Action ID No. 2010-02125

Reference the Department of the Army (DA) individual permit (IP) issued to you on September 27, 2013, to impact approximately 6.94 acres of Department of the Army (DA) jurisdictional wetlands and 851 linear feet of surface waters associated with NCDOT TIP No. R-3307; Gallants Channel Bridge, related approaches, and upgrades to US 70 located near the town of Beaufort, Carteret County, North Carolina.

This office received permit modifications dated November 20, 2015 and December 16, 2015, affecting areas of the above referenced project. The modification requests are detailed as follows:

Subject: Modification to the 401 Water Quality Certification Pursuant to Section 401 of the Federal Clean Water Act with ADDITIONAL CONDITIONS for Proposed improvements to US 70 from the existing four lanes at Radio Island to US 70 north of S.R. 1429 in Carteret County in, Federal Aid Project No. No. STPNHF-70(43), State Project No. 8.116250, TIP R-3307.
NCDWR Project No.20111003 v. 6

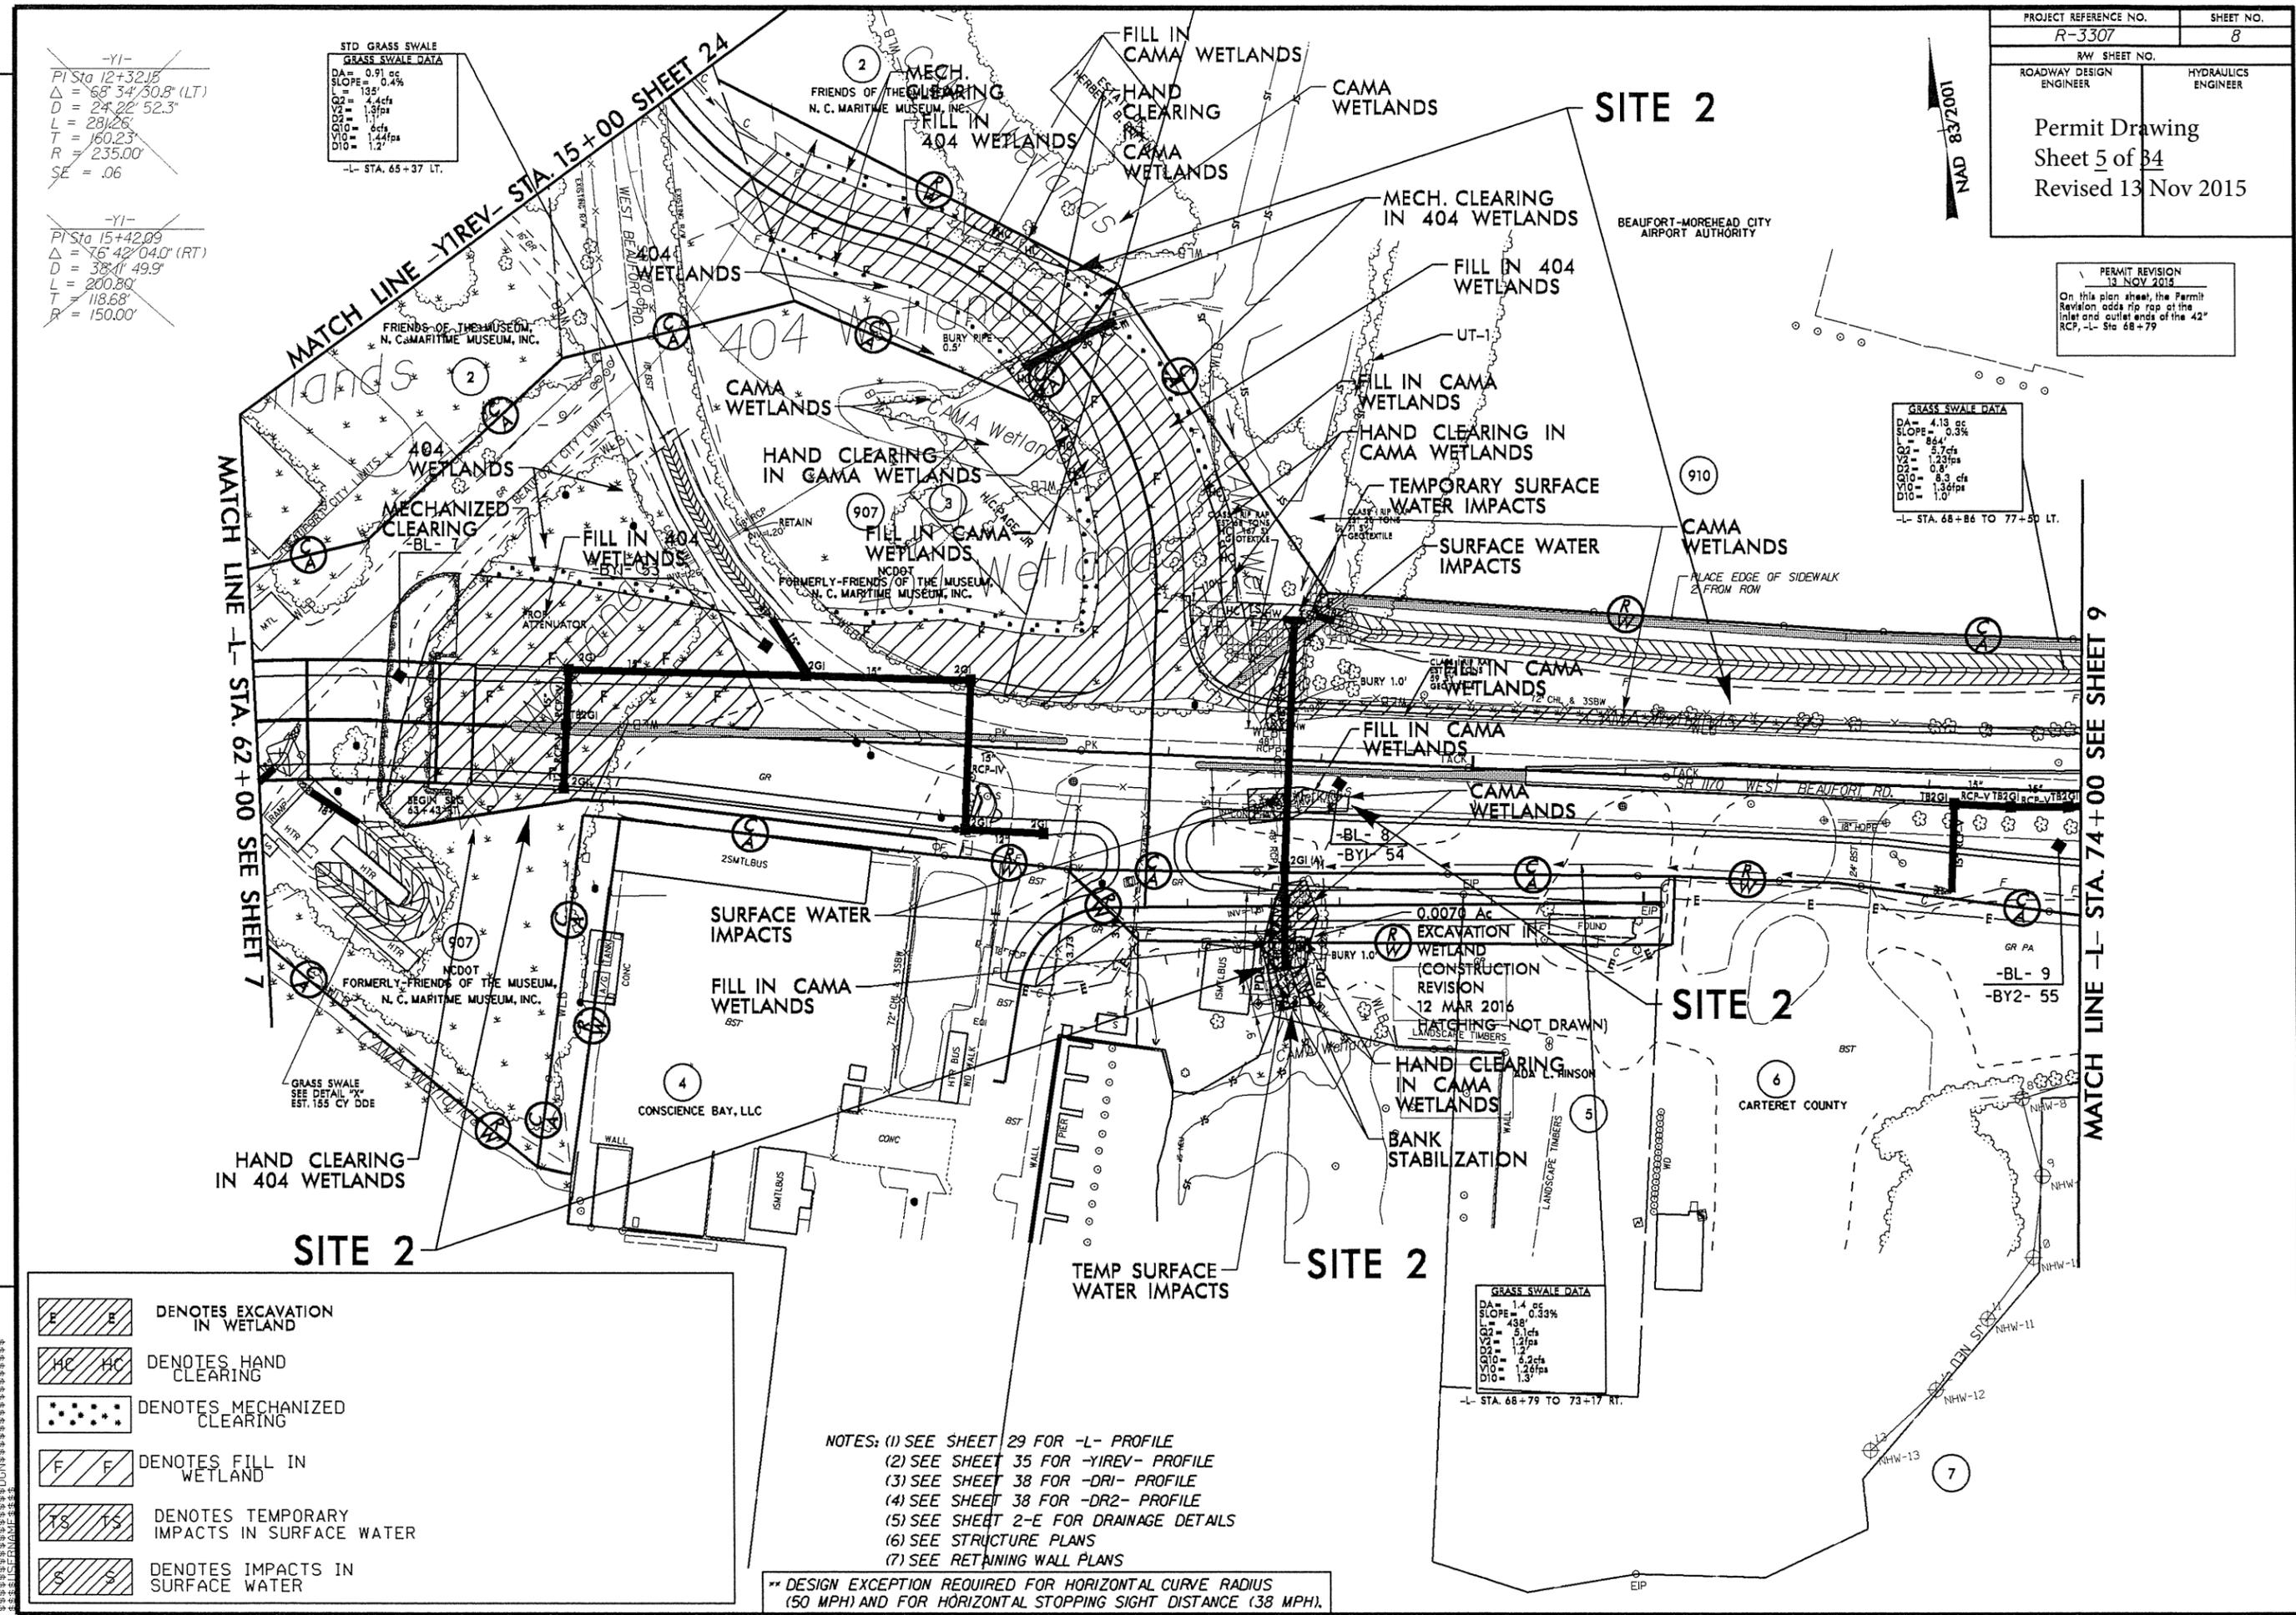
- 2). Permit drawing sheets 6 and 7 have been revised to show the removal of small bridges and pipes along a channel adjacent to the Beaufort Morehead City Airport. As discussed in the field on January 5, 2016, these will not be replaced. An existing 60" pipe on the northern extent of the channel may require removal and replacement with a structure of similar size and length is allowed without further permitting. A structure of any additional length will require notification to the Corps.
